LATIGO TRAILS FILING NO. 10 EL PASO COUNTY, COLORADO PUBLIC UTILITY PLANS

MSMD SECOND REVIEW

PUBLIC UTILITY PLANS FOR: LATIGO TRAILS FILING NO. 10 EL PASO COUNTY FALCON, COLORADO

**WS-1**

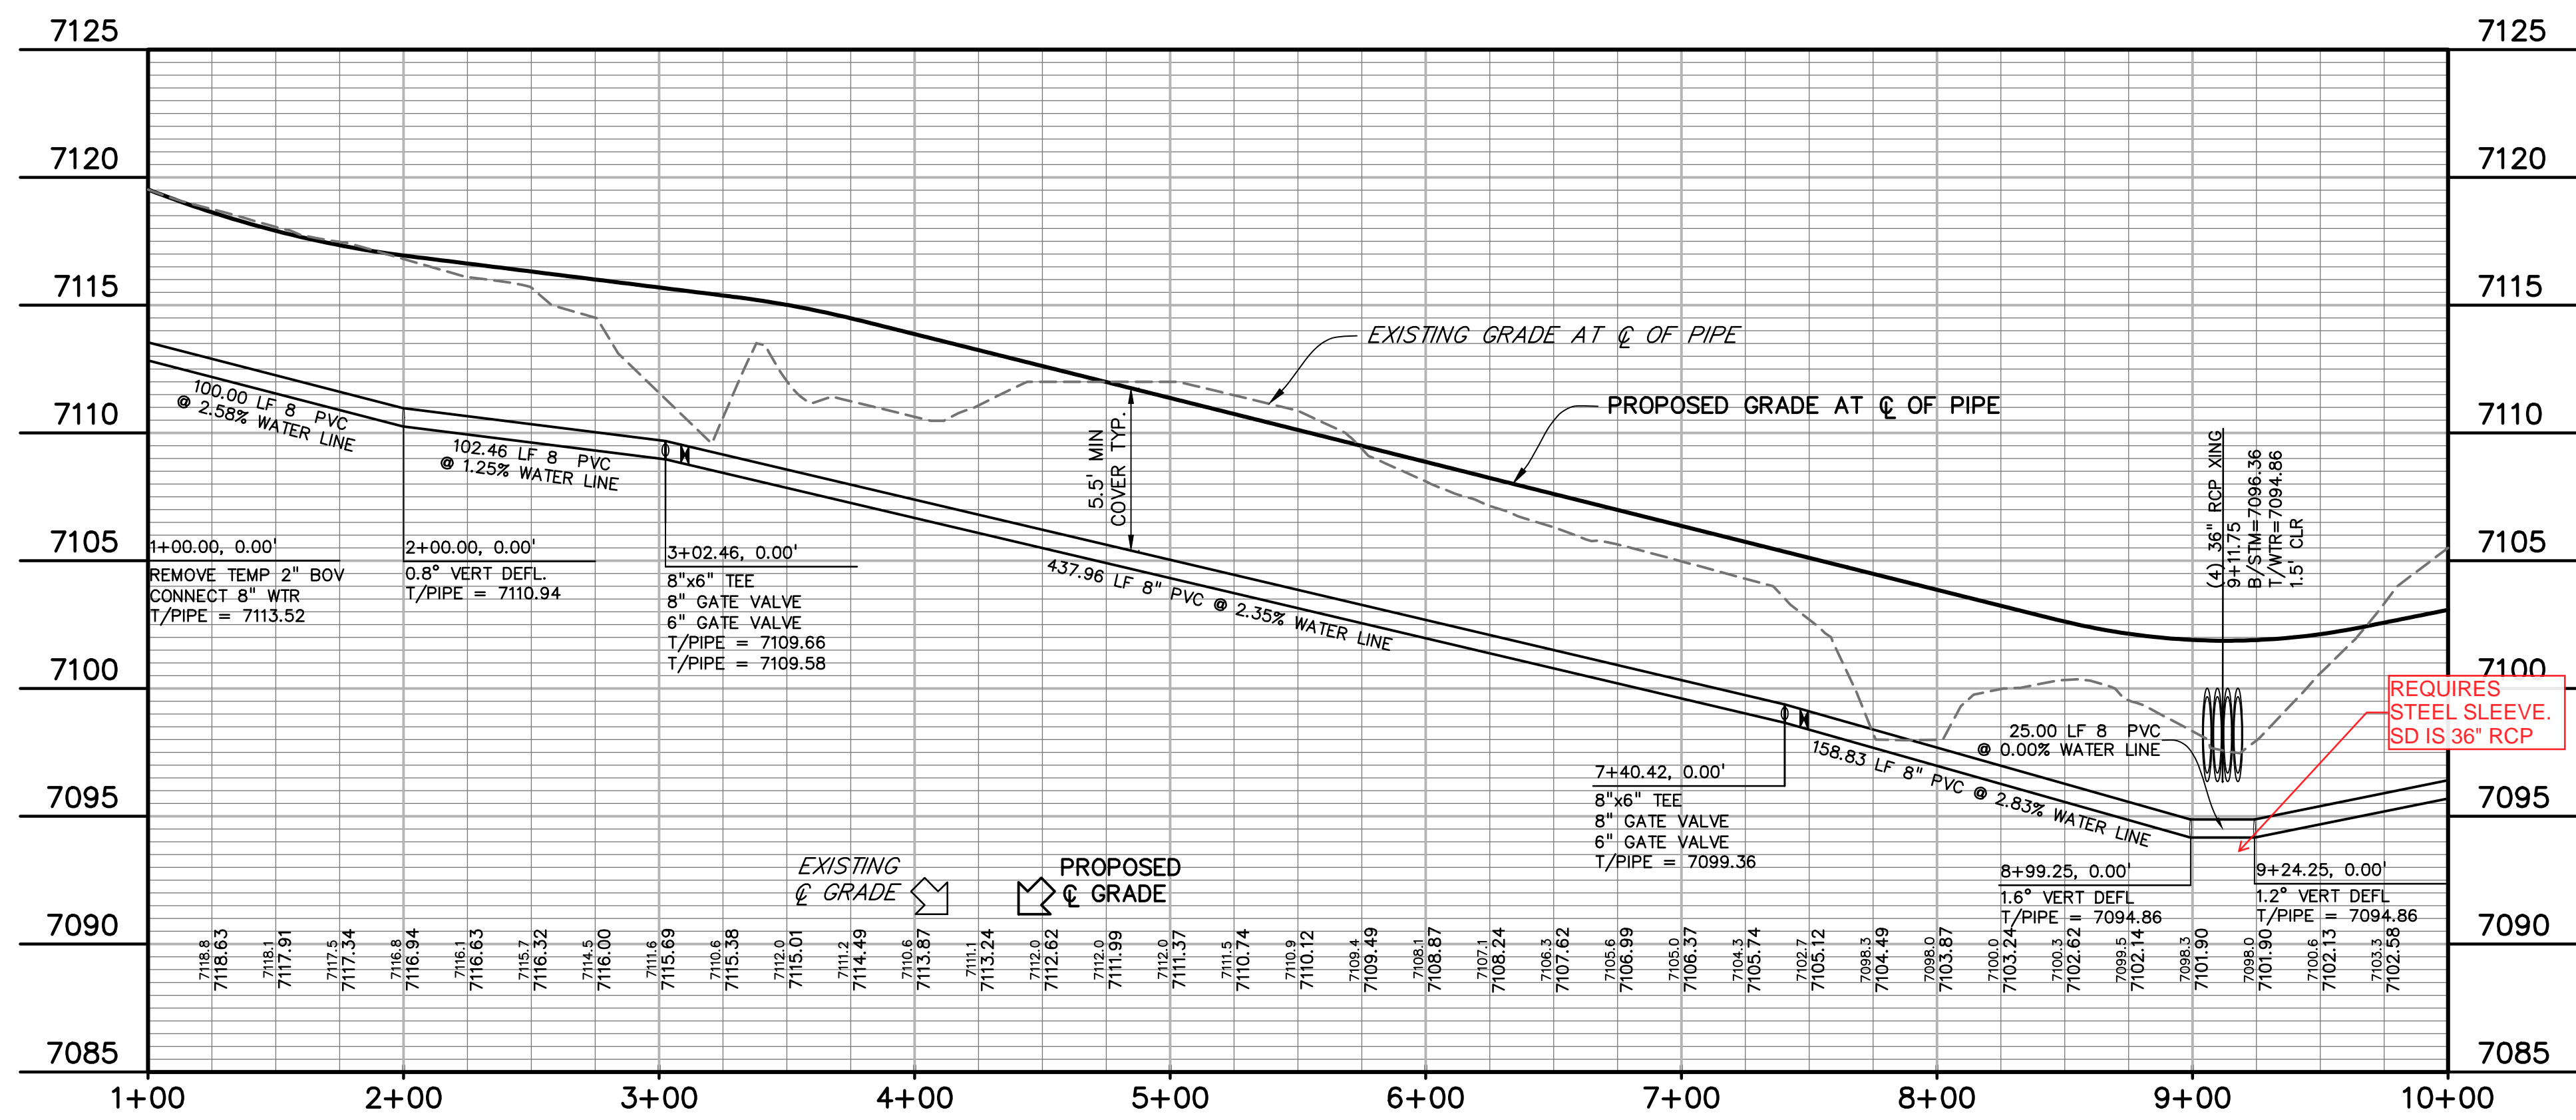
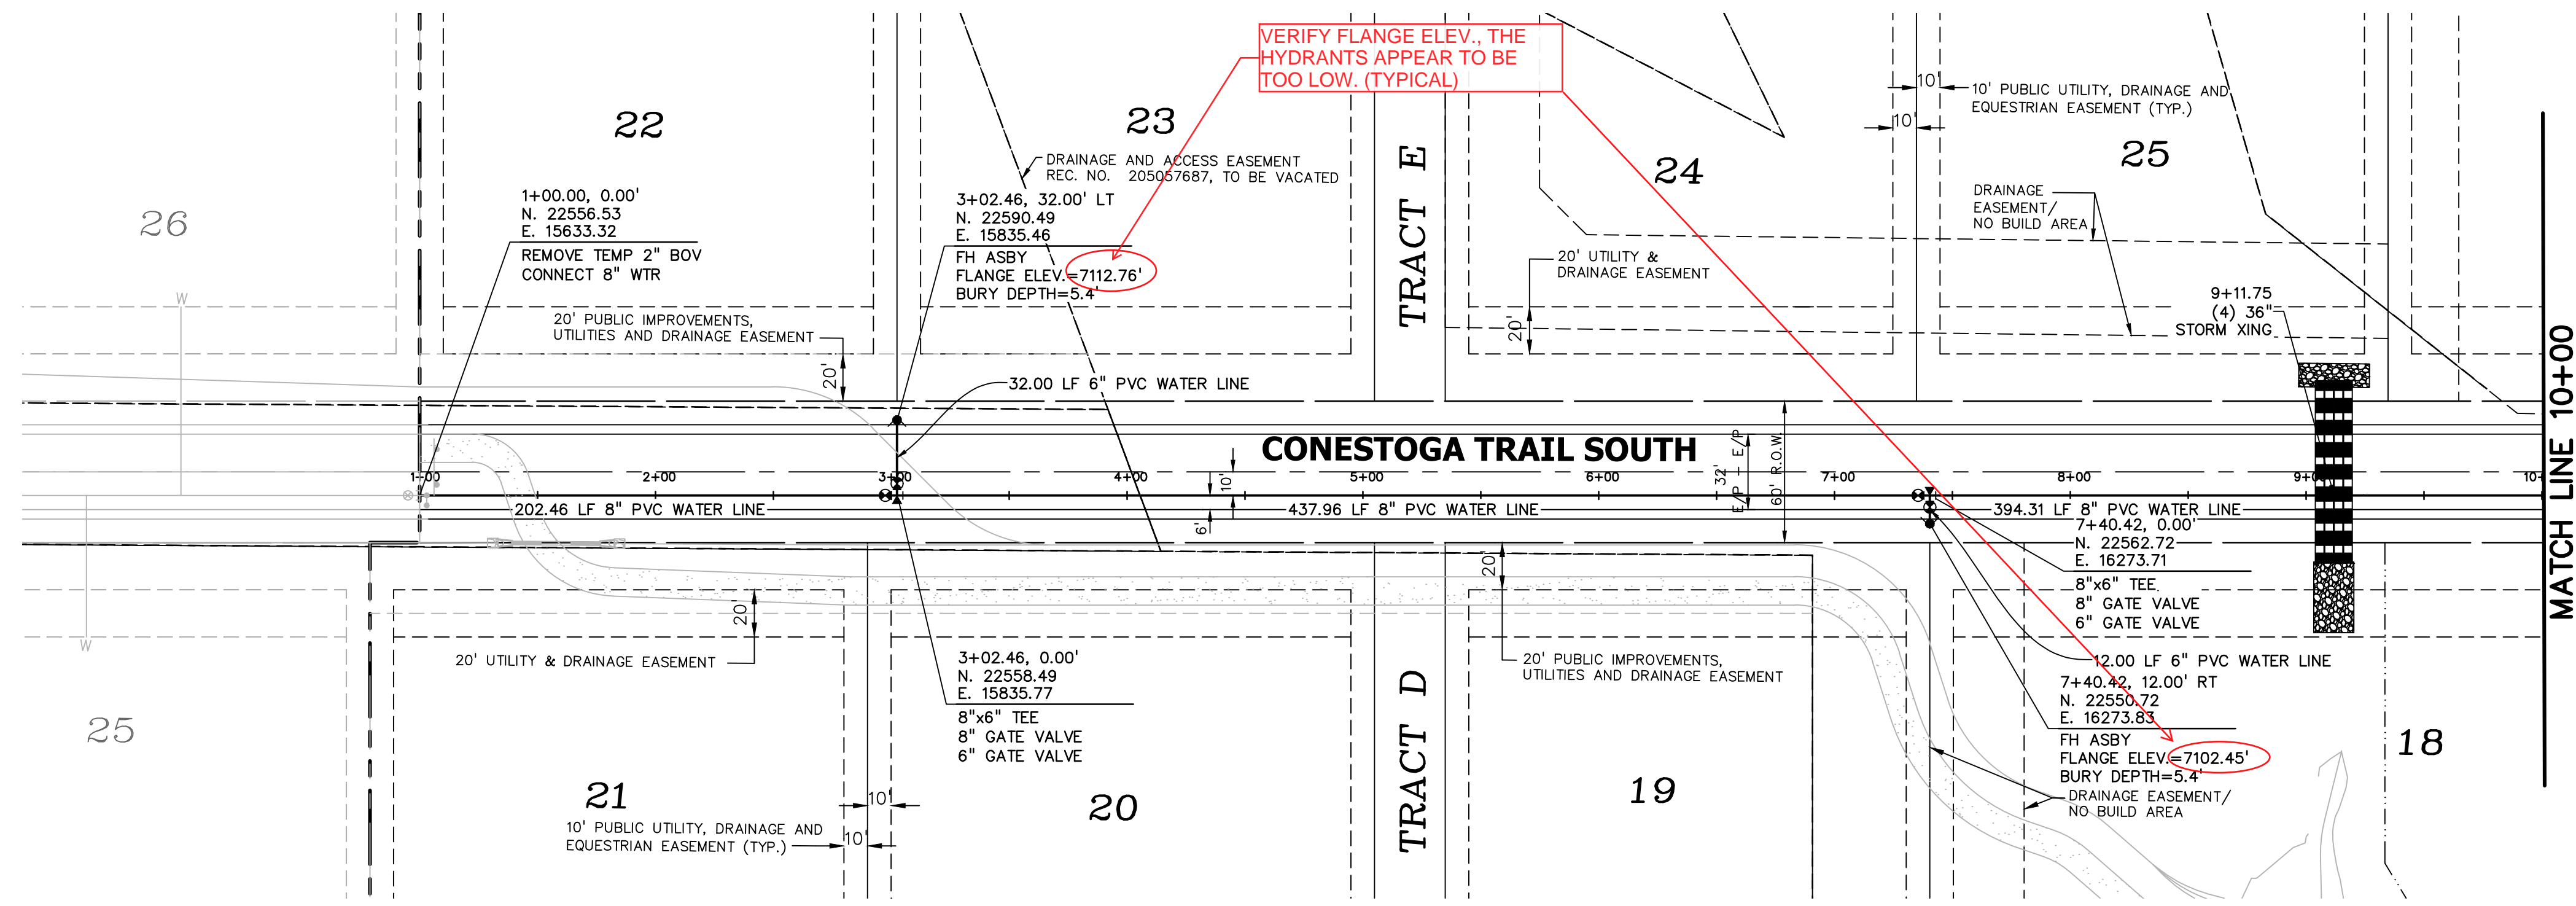
PROVIDE A TYPICAL CROSS-SECTION OF THE HYDRANT LOCATION FOR THIS PROJECT THAT MATCH THE PROPOSED STREET SECTION. I.E. WITHOUT CURB & GUTTER.
